Amendments to Approved Level II Site Plan – Ocean Gateway Addition

Project: Ocean Gateway Addition

To: Level II Site Plan Staff

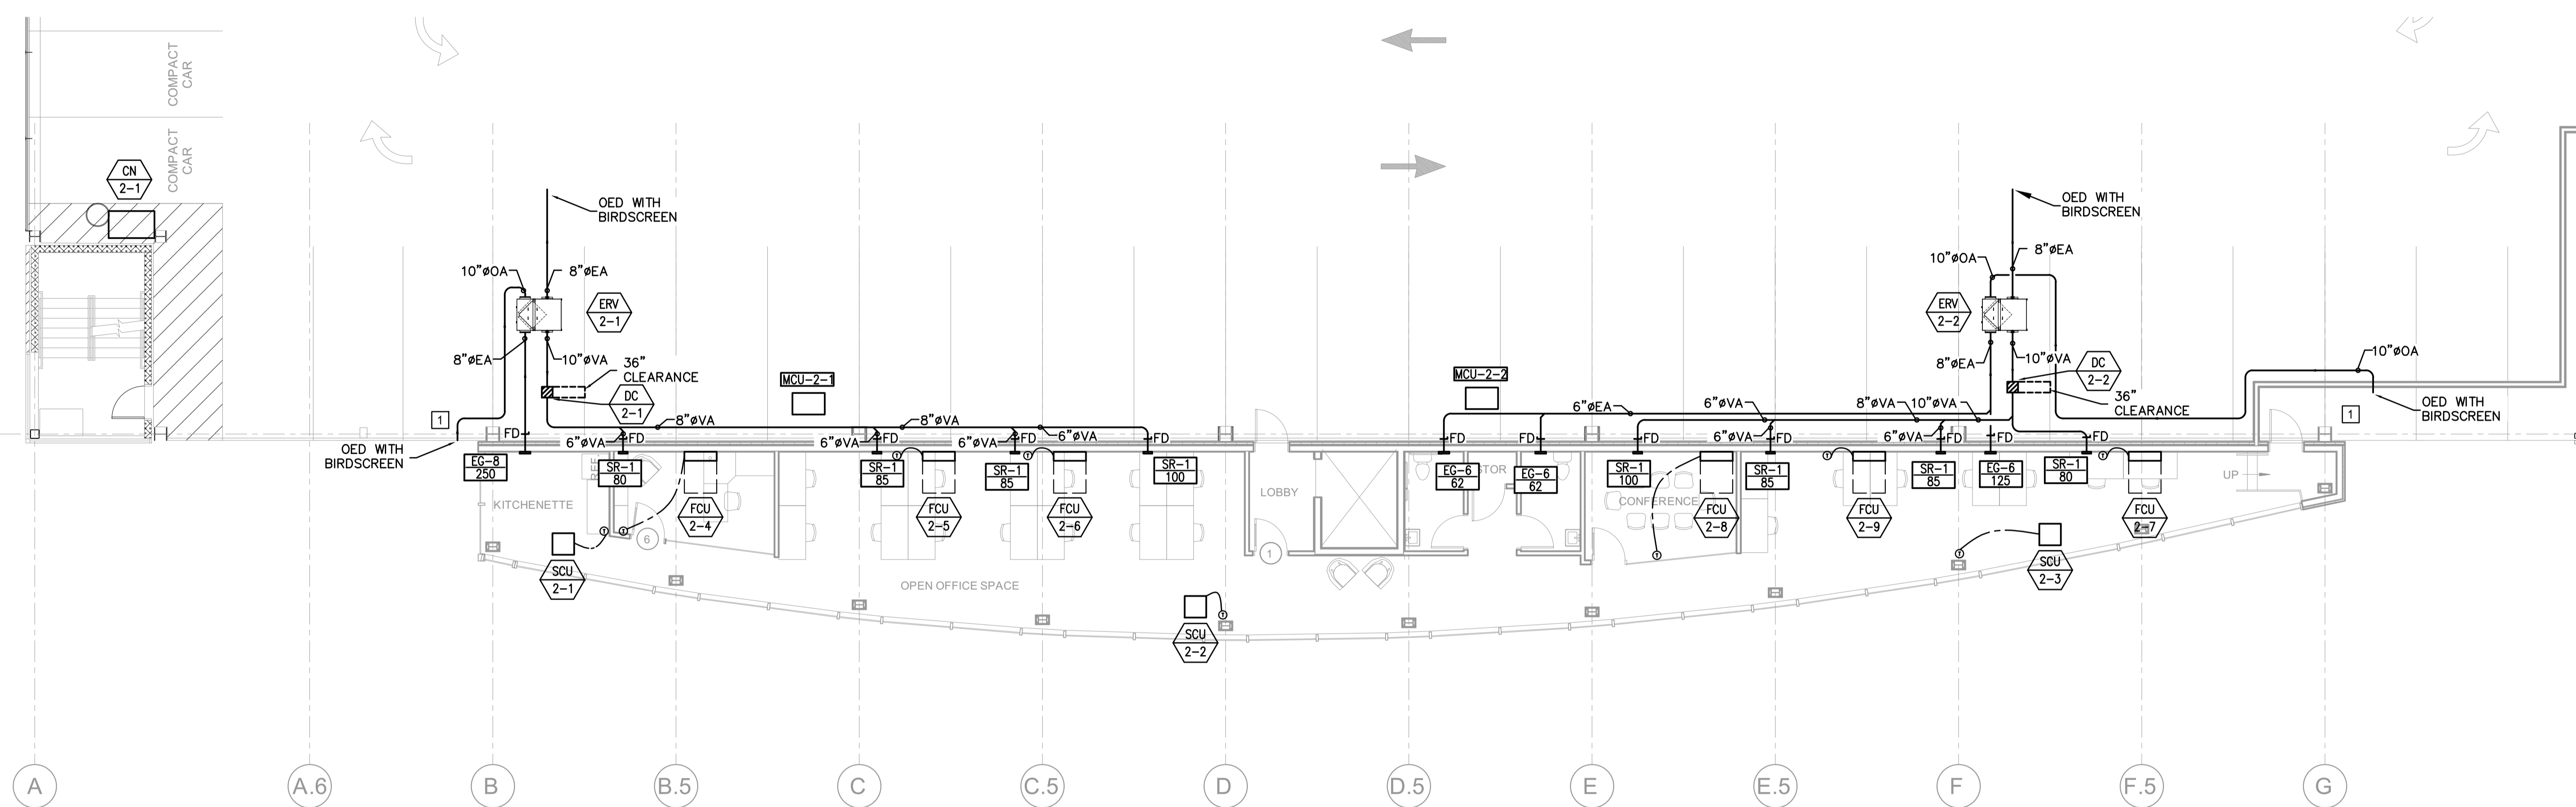
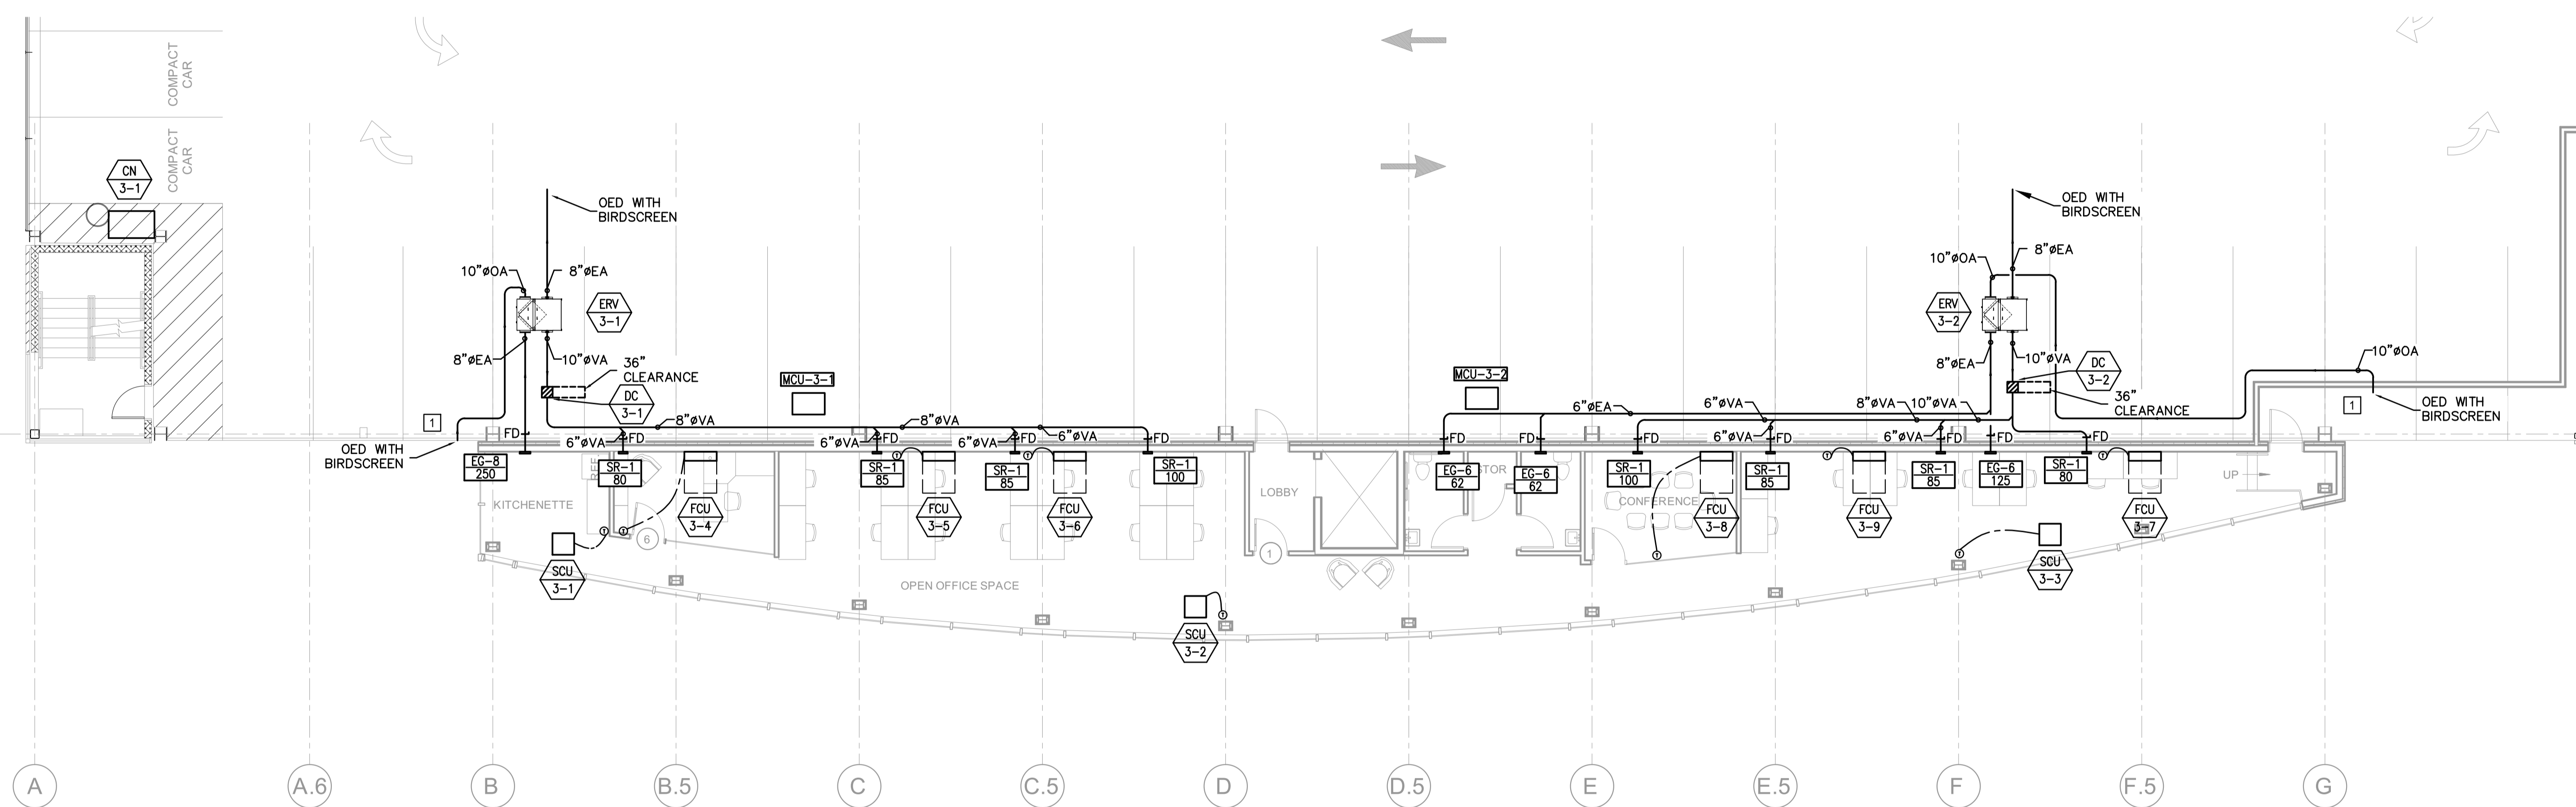
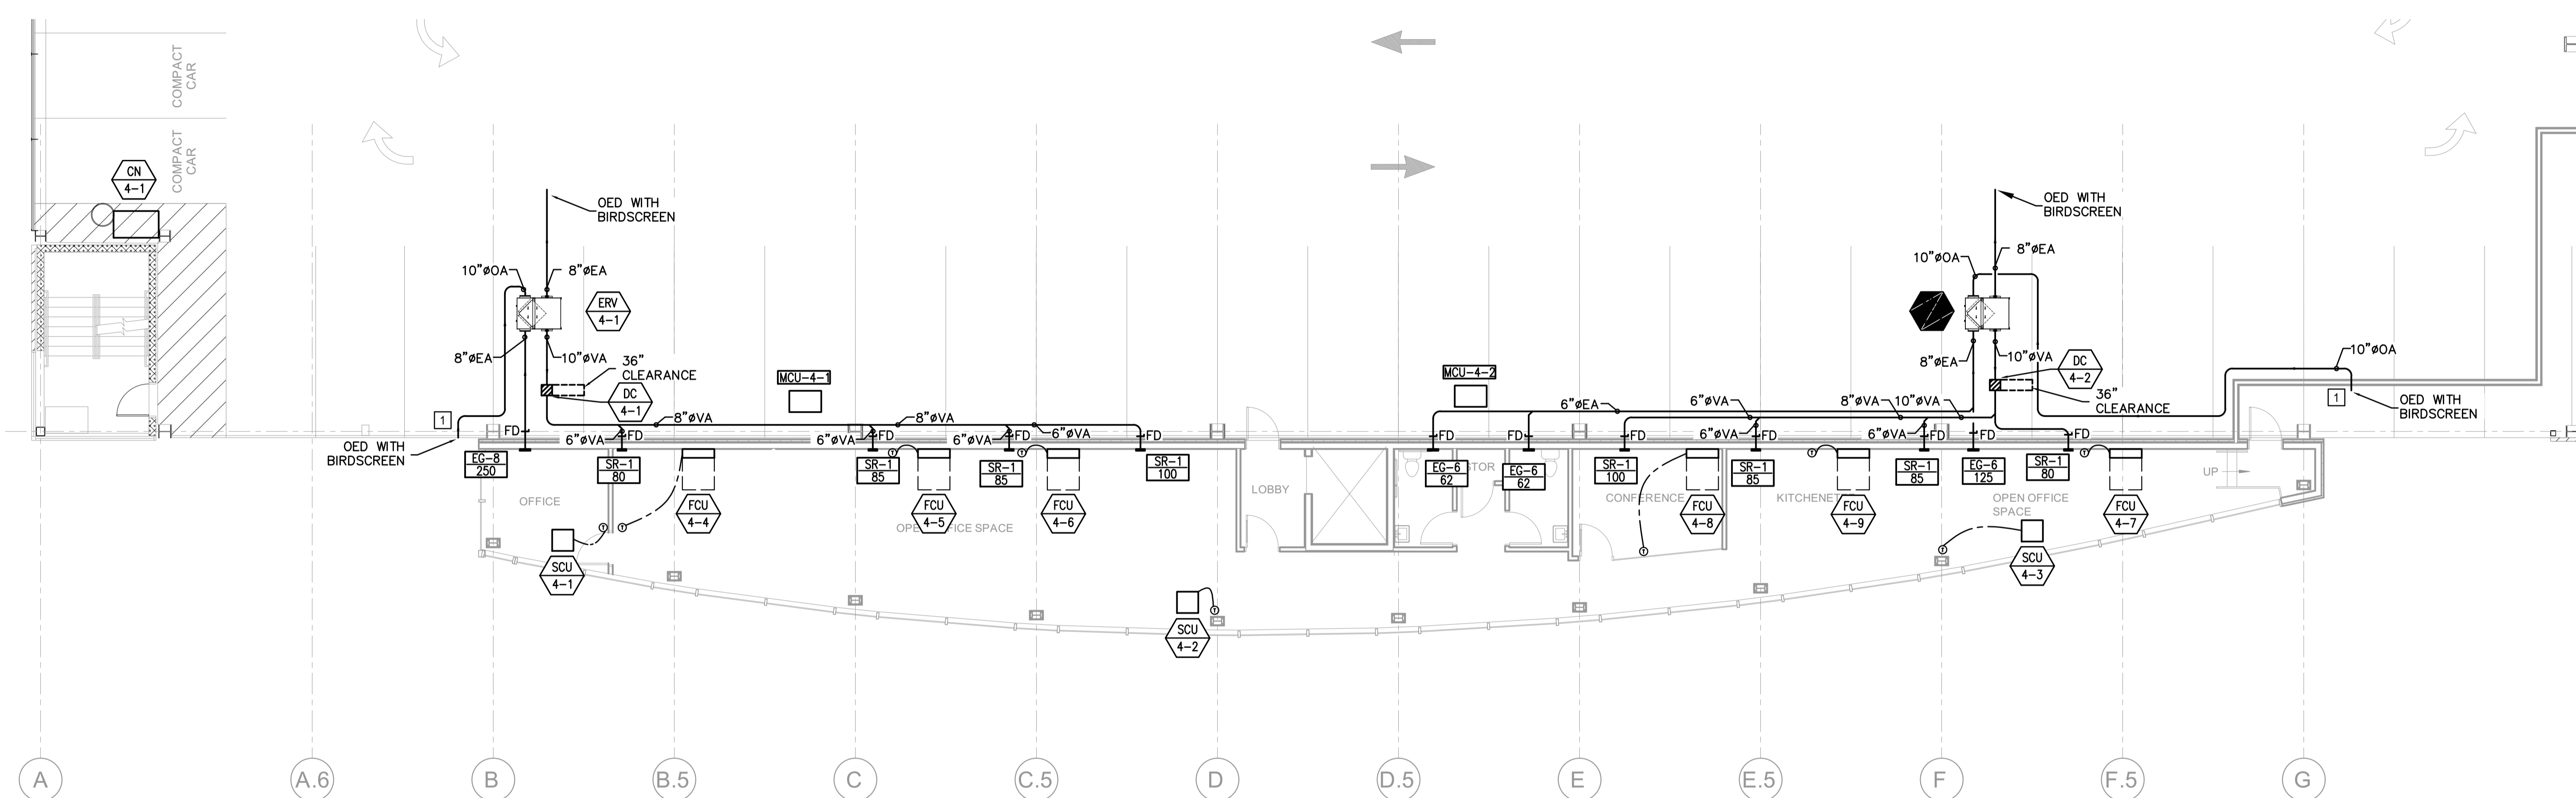
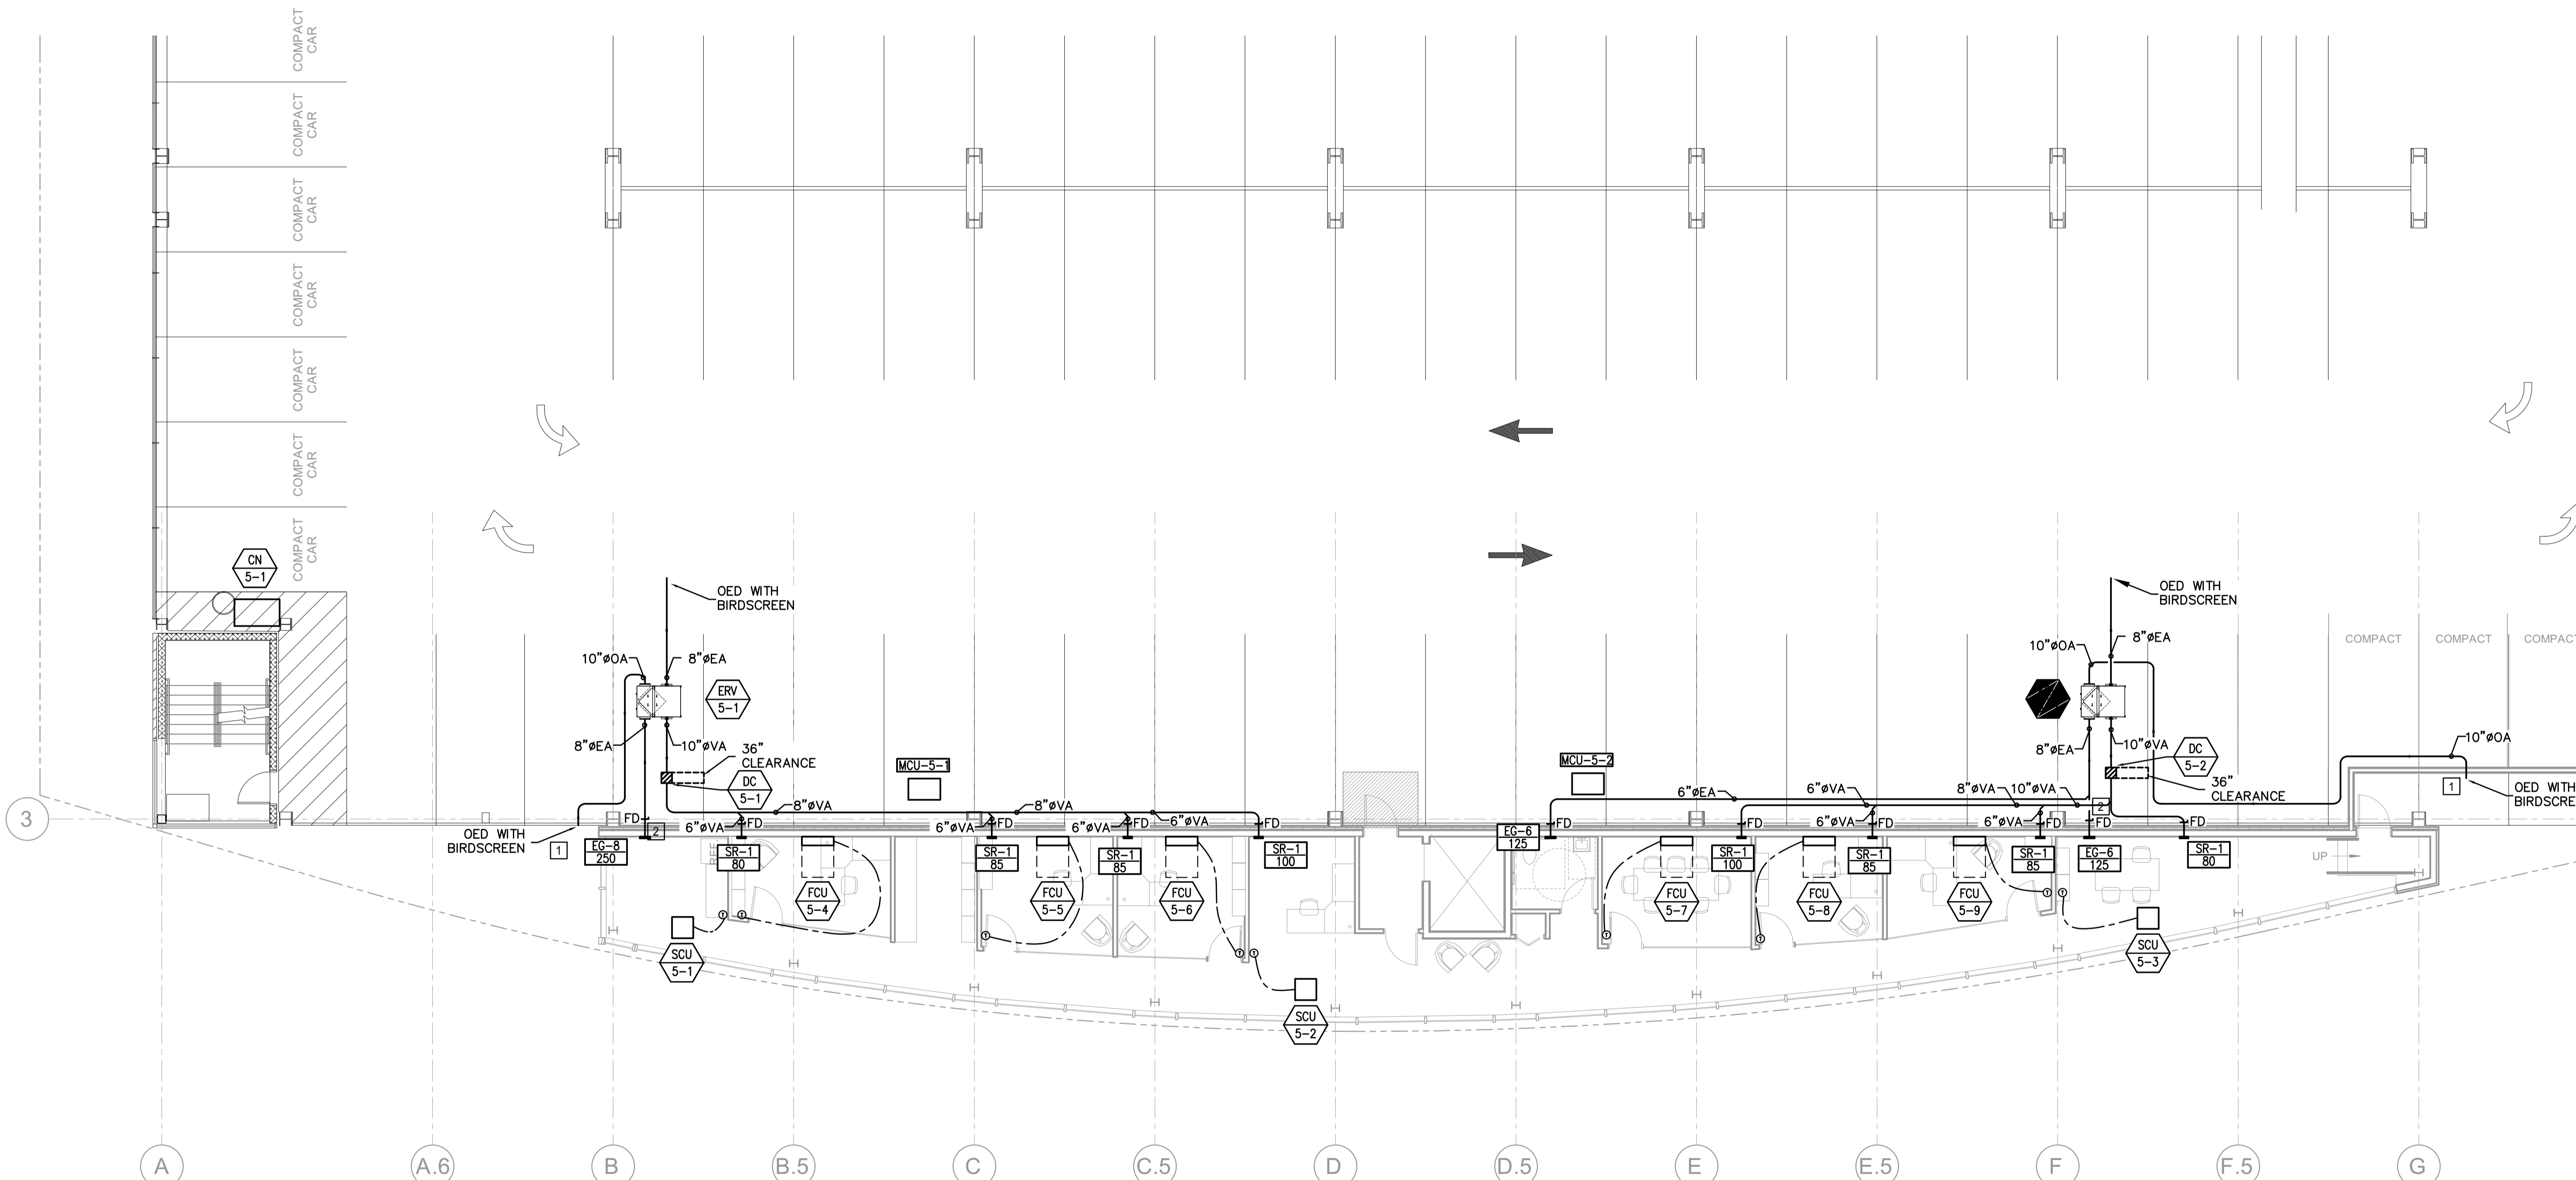
We have switched from rooftop mechanical units to wall mounted units at each floor. These units will be mounted on demising wall between addition and garage, and will not impact any of the parking spaces within the garage.
